Application by Green Hill Solar Farm Limited for Green Hill Solar Farm [EN010170]

The Examining Authority's written questions and requests for information (ExQ2): Issued on 28 November 2025

Responses are due by deadline 3: 17 December 2025

Title:
Figure 13.15: Access Locations for Sites and
Cable Route Corridor (South Area Part 1)

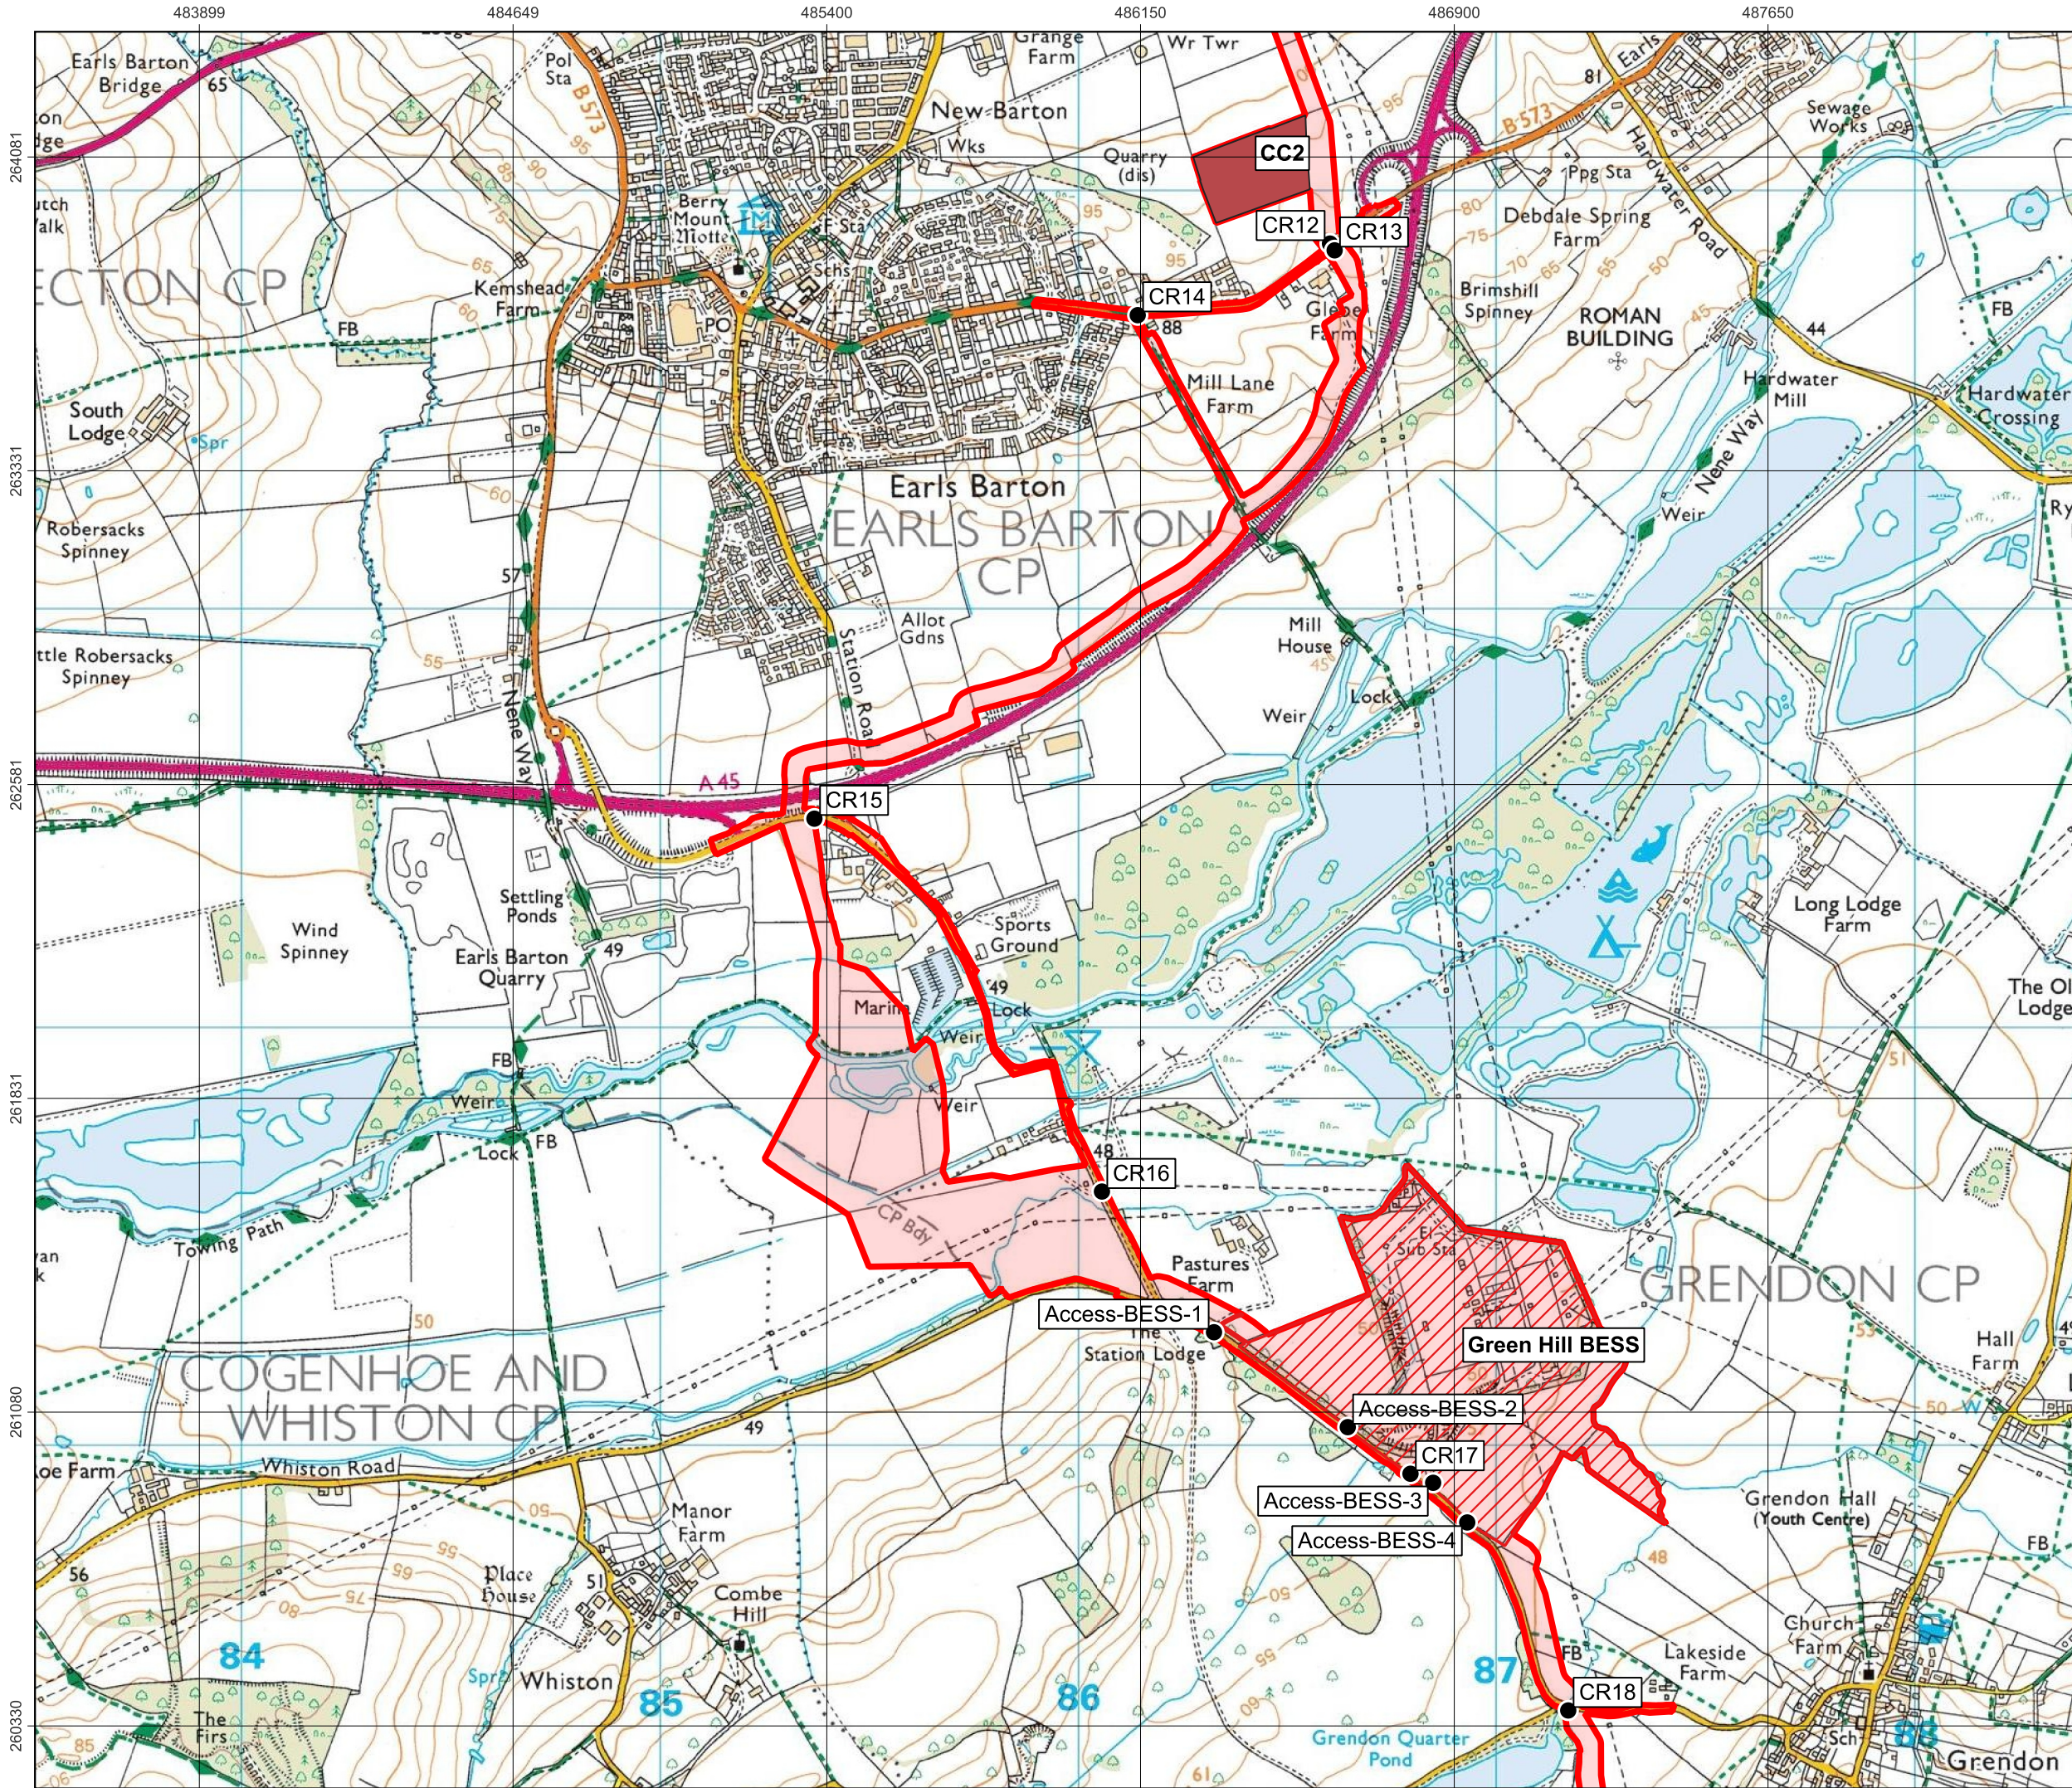
Q2.16.4	The applicant	Access to Construction Compound 4 Construction Compound 4 would be accessed via an internal haul route from Station Road, Grendon. Horizontal directional drilling (HDD) would be used in the vicinity of the Station Road terminus of the haul route in respect of Crossings HV_SP8760_013 and HV_SP8760_014, as shown in the Crossing Schedule [APP-562]. The applicant’s response to Question Q20.0.3 of the Examining Authority’s First Written Questions [REP1-163] states that where HDD is used, internal haul routes cannot be used to inter-connect between sites. Can the applicant explain how a haul route would be made available from Station Road.
Q2.16.5	The applicant	Access D-1 (Highfield Road) The applicant’s response to Q20.0.12 [REP1-163] sets out that Access D-1 has been identified for use during the construction phase and during replacement periods. The access would lie close to the Sywell Road junction with Highfield Road. A representation [REP1-207] has been made regarding the safety of this access. What assessments of the highway safety implications of its use have been made?

Title:
Figure 13.10 (Rev A): Public Rights of Way
within the Study Area (North Area)

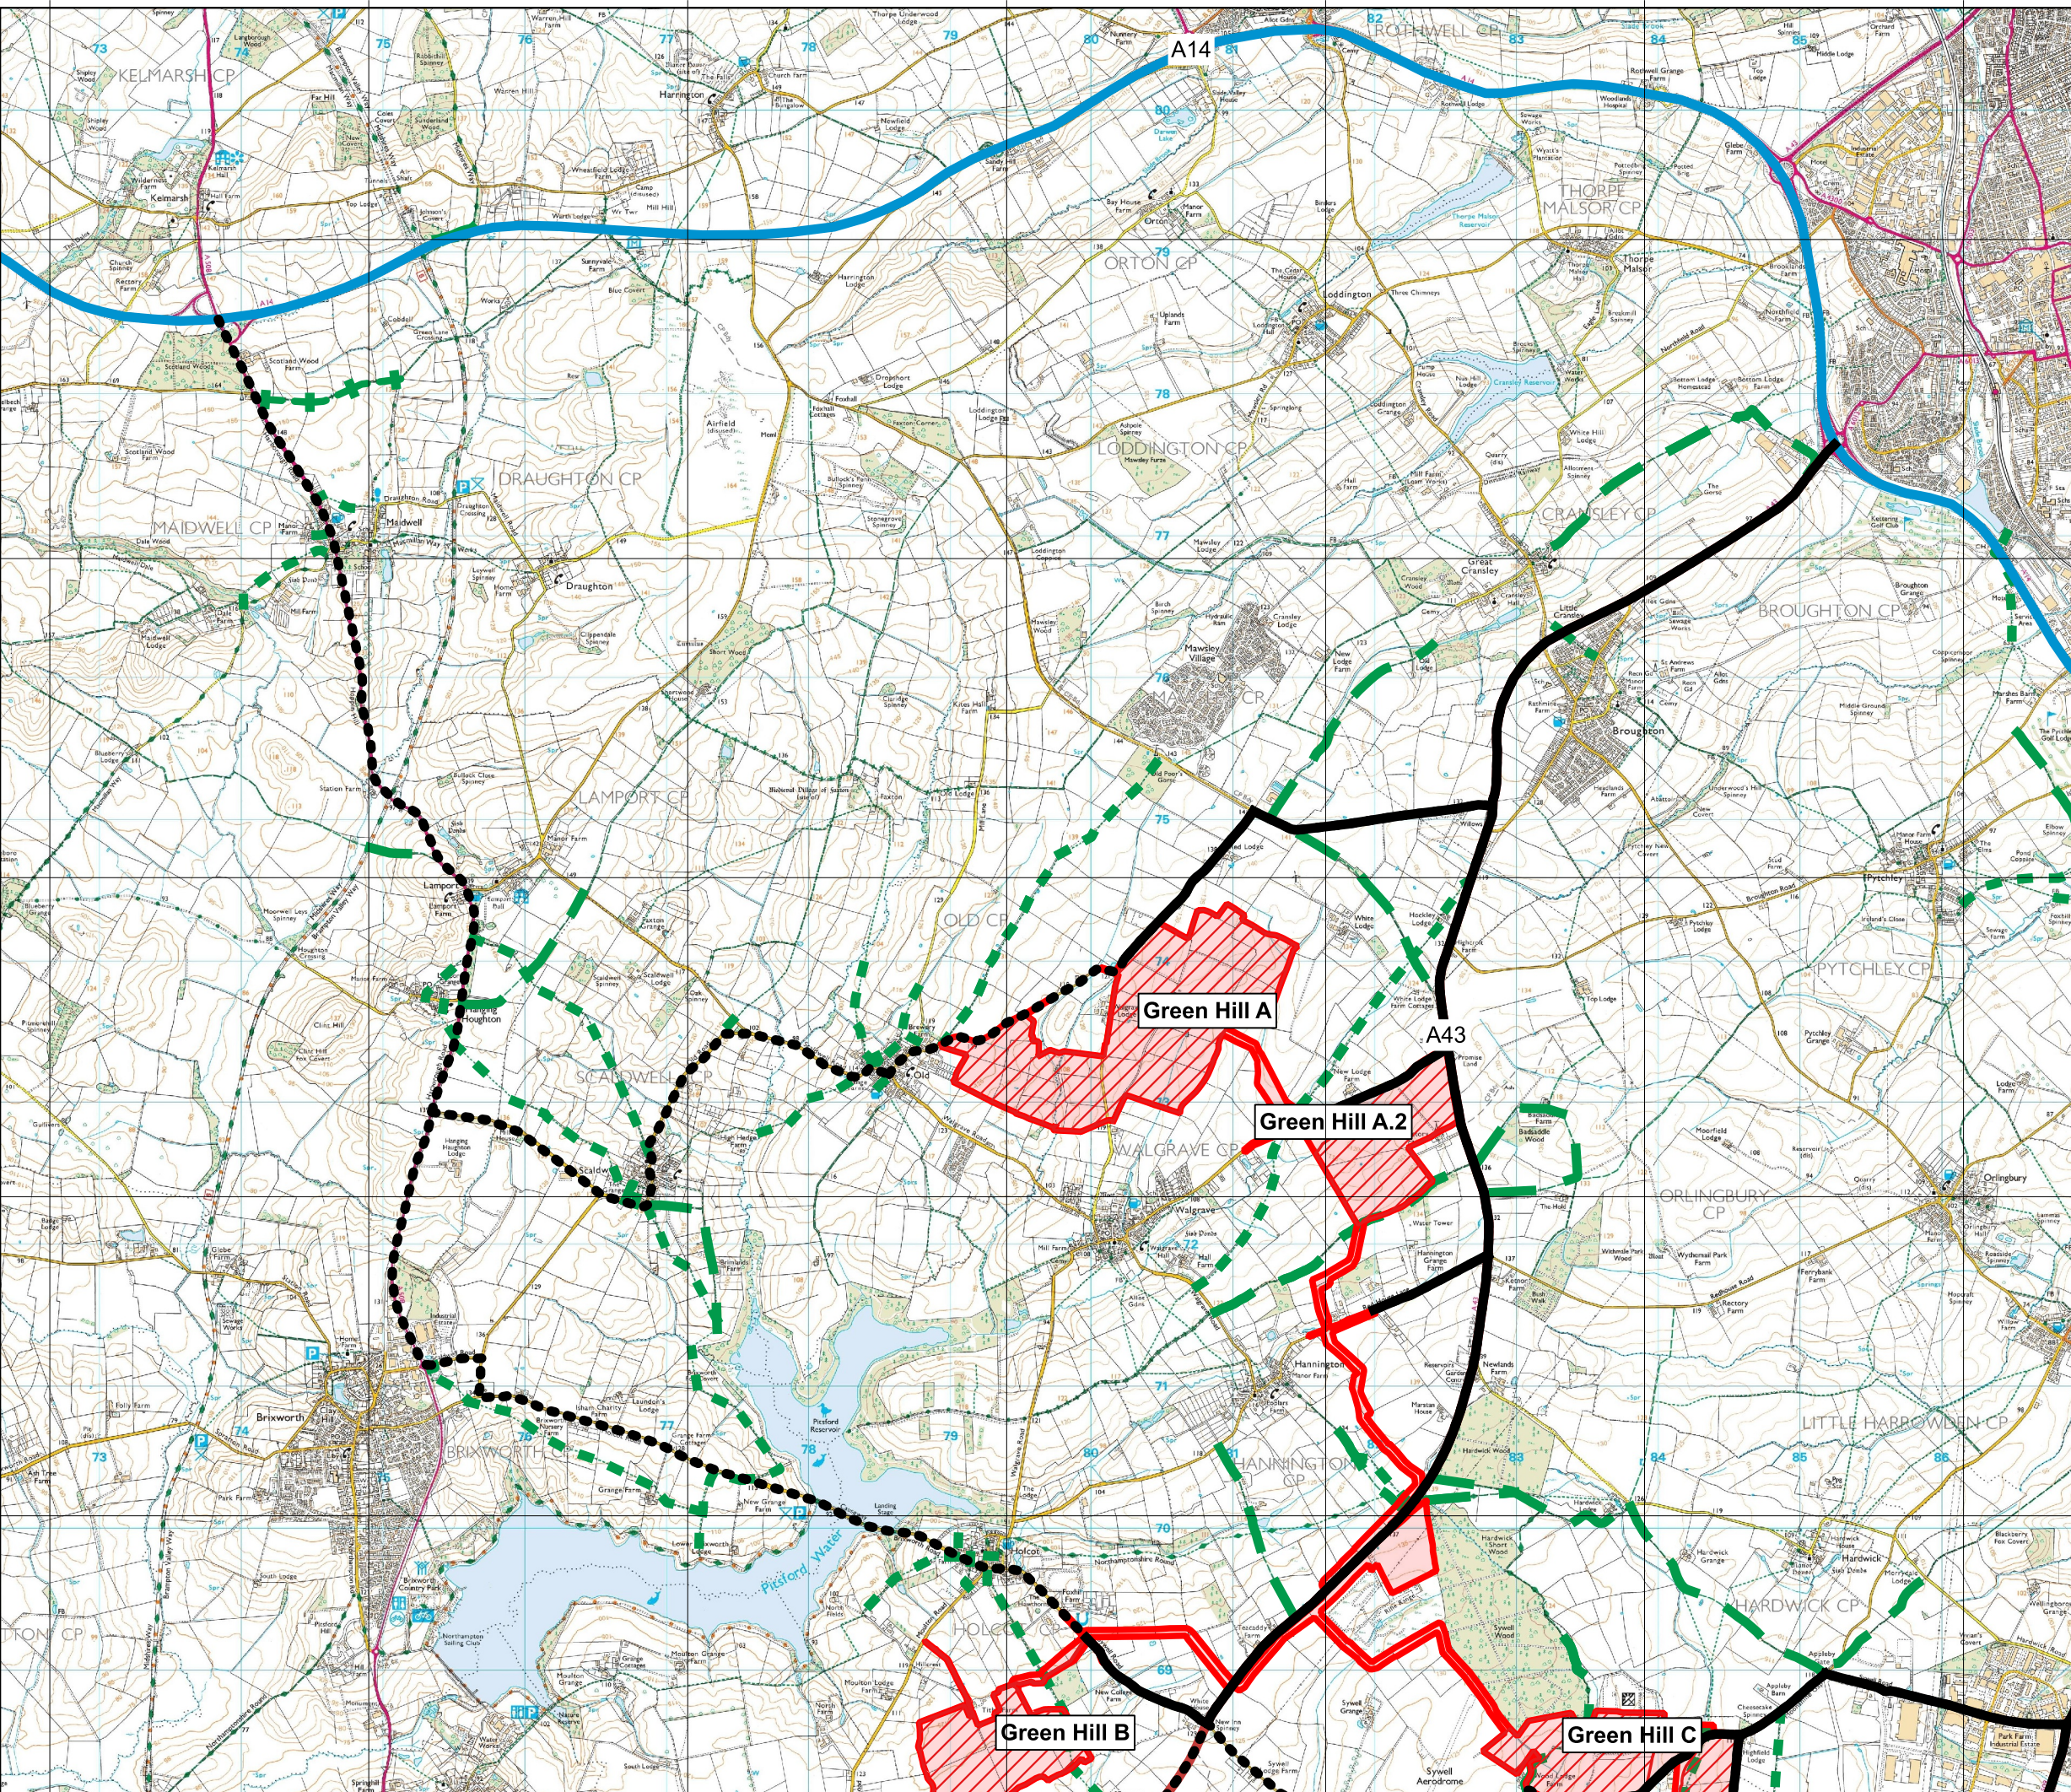
Q2.16.6	The applicant	Notice of public right of way closures West Northamptonshire Council’s Local Impact Report requests that notice is given to the public of any temporary closures of public rights of way. Please confirm whether any updates to the Outline Public Rights of Way and Permissive Paths Management Plan (Revision A) [REP1-147] in this respect are considered appropriate.
Q2.16.7	The applicant	Consideration of management measures to prevent diversions or closures of public rights of way The Outline Public Rights of Way and Permissive Paths Management Plan Revision A [REP1-147] sets out (at 3.2) management measures for the tabulated public rights of way which would need to be crossed during construction or which would require management associated with the Cable Route Corridor. However, any management measures which would be considered before closures in respect of several other public rights of way which may be subject to temporary closure, such as Footpath TF/004 between Grendon and Castle Ashby, are not set out. Given the value placed on countryside access by local communities, can the applicant explain whether consideration of such management measures in preference to diversions or closures would be given in respect of all affected public rights of way?
